PLANNING - LEVEL III REVIEW (14-526): MMC Congress Street Medical Building (285KSF) (19 procedure rooms, 64 patient rooms, licensed bed count remains 637)
Institutional Overlay Zone

IOZ - ZONING ANALYSIS

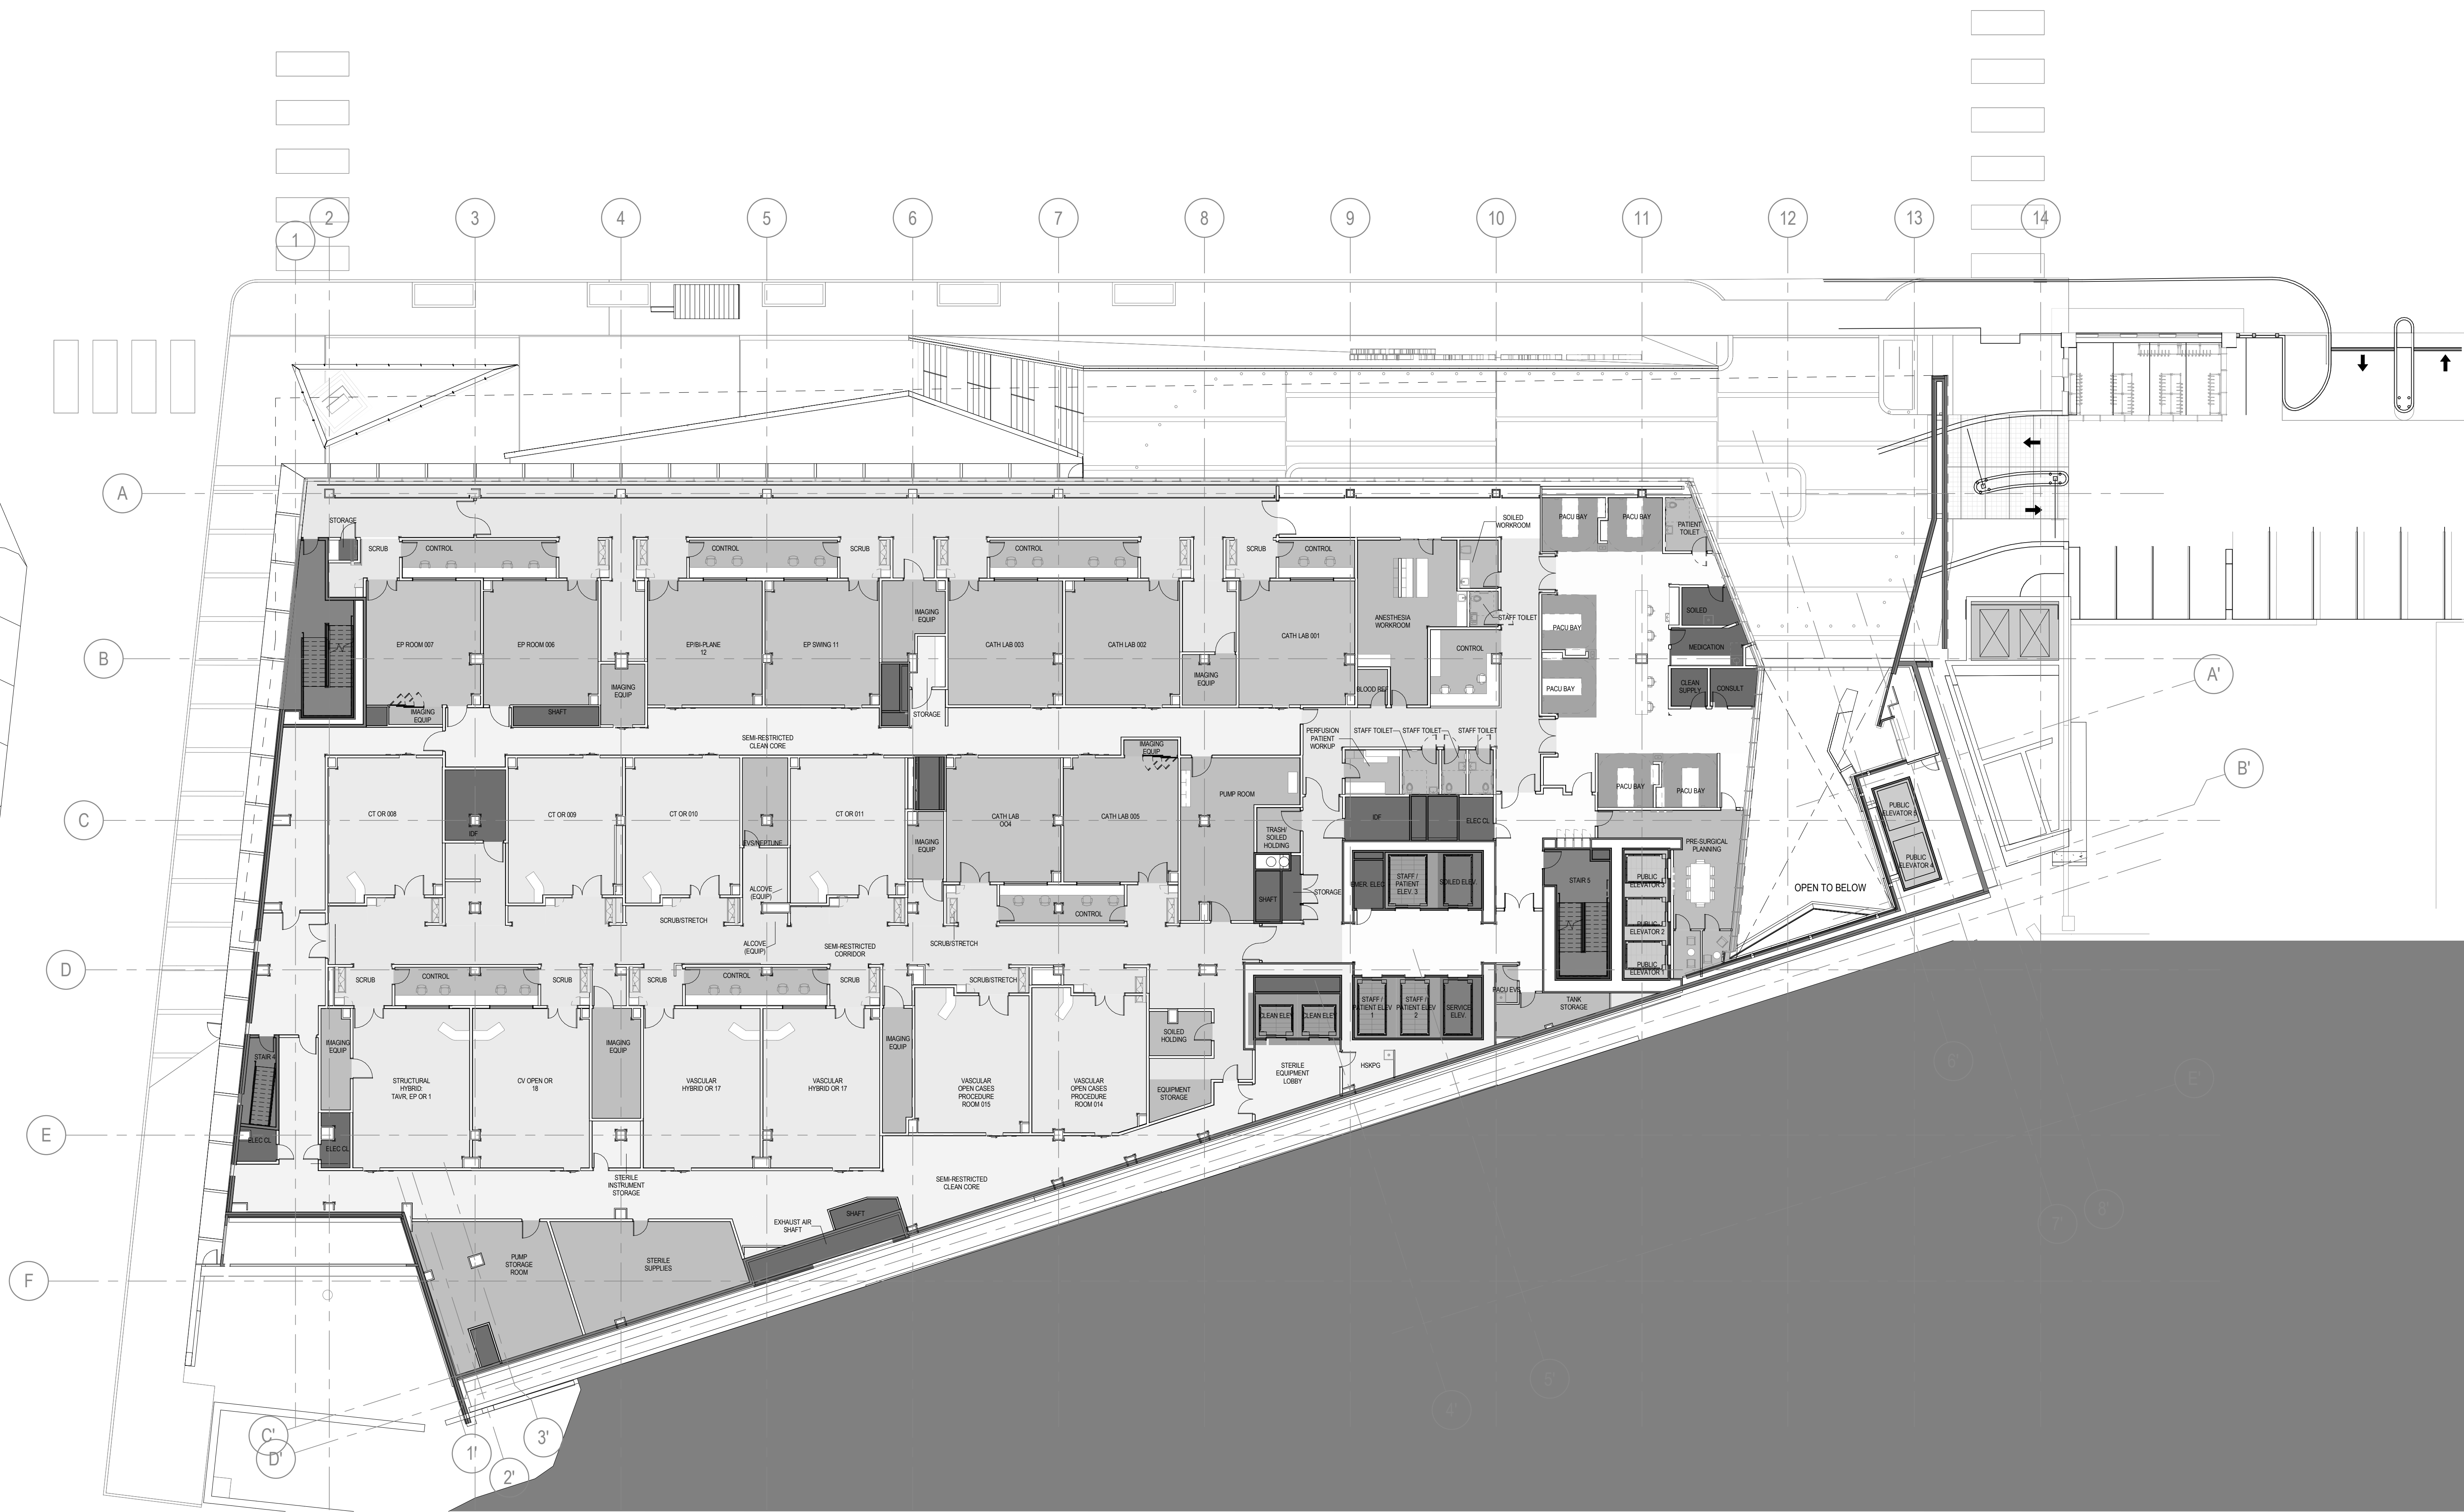
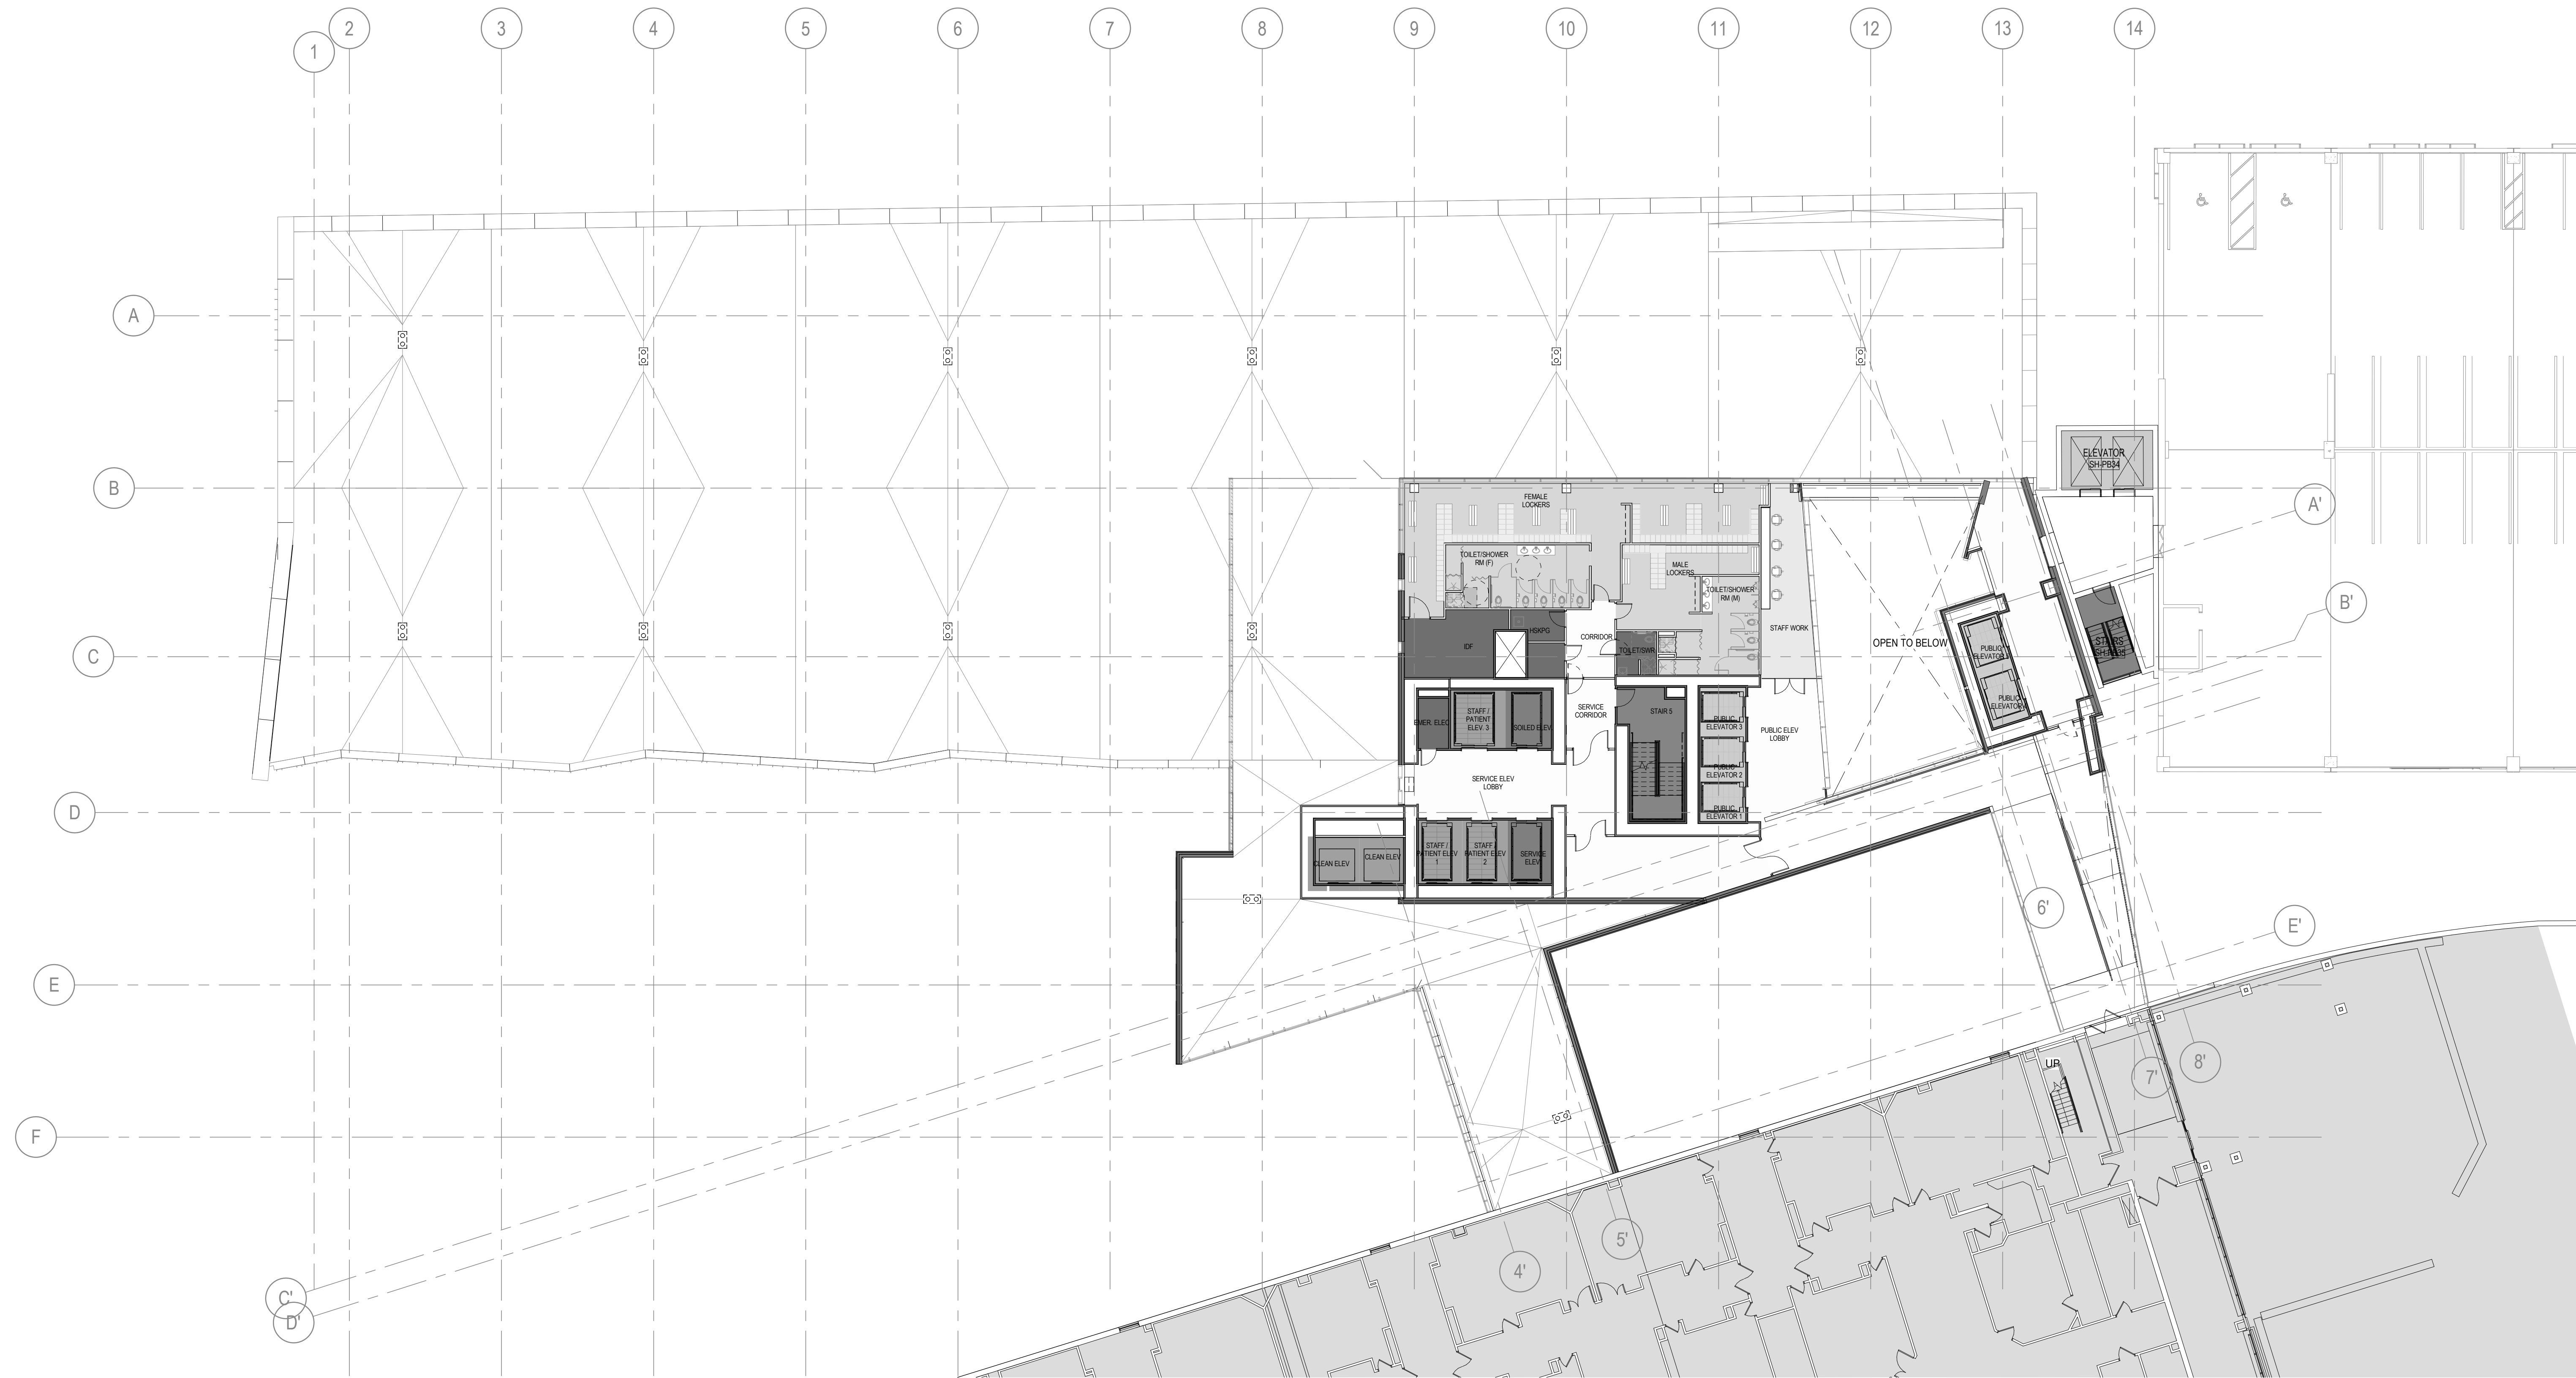
i. Zoning Related Design Standards	See comments from others.	Floor plans Roof plans Sections Please provide rendering of main entrance from ground plane if possible.

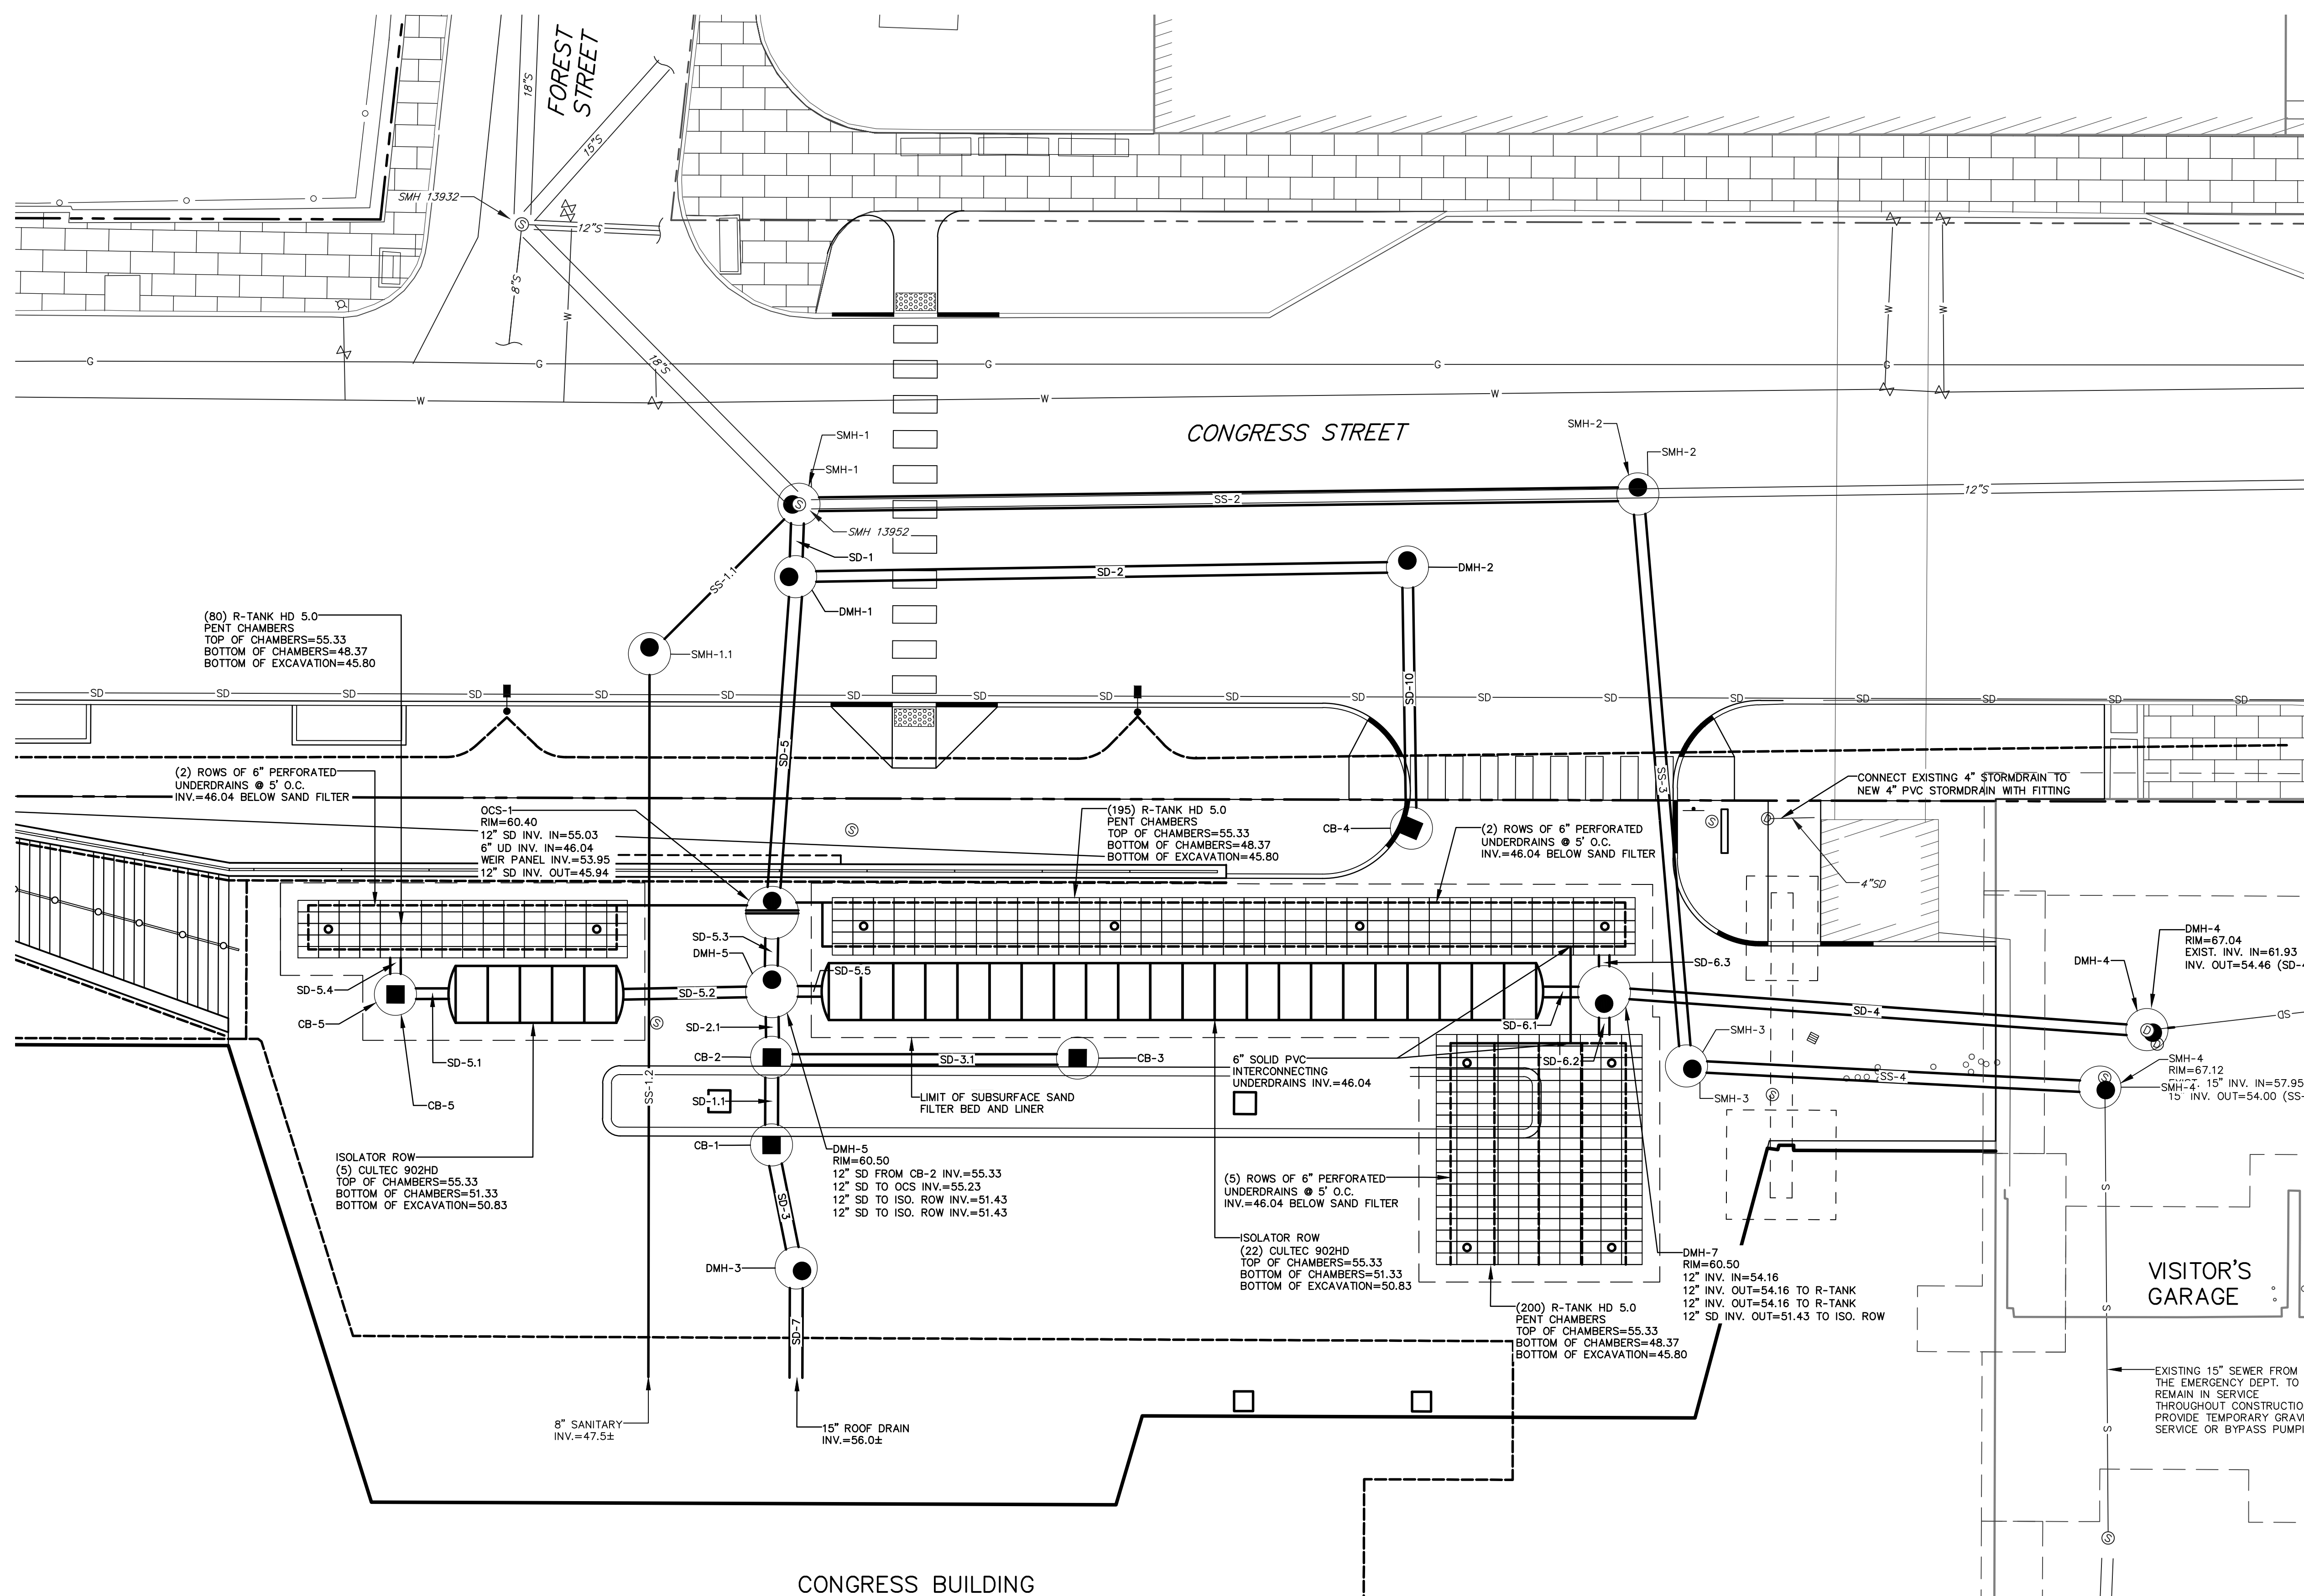
c. Availability and Adequate Capacity of Public Utilities	Utility plans are still under review.	See comments from others Please clarify extent of utility infrastructure in Gilman Street ROW, particularly electrical infrastructure?
Site Design	a. Massing, Ventilation and Wind Impact

- rescale site plan at 1" = 20'
- include distances to property lines on site plan
- add height calculation from average grade on elevations (Still under review)
- ~~plans need to be stamped by an engineer~~
- ~~Can you confirm which utility poles are staying and which will be removed? Any remaining utilities & poles should be shown on the revised utility plan.~~

Encroachments (building encroachment, 'mechanical areaway', potentially electrical/other utility infrastructure) are shown in the Gilman ROW. These will require license agreements
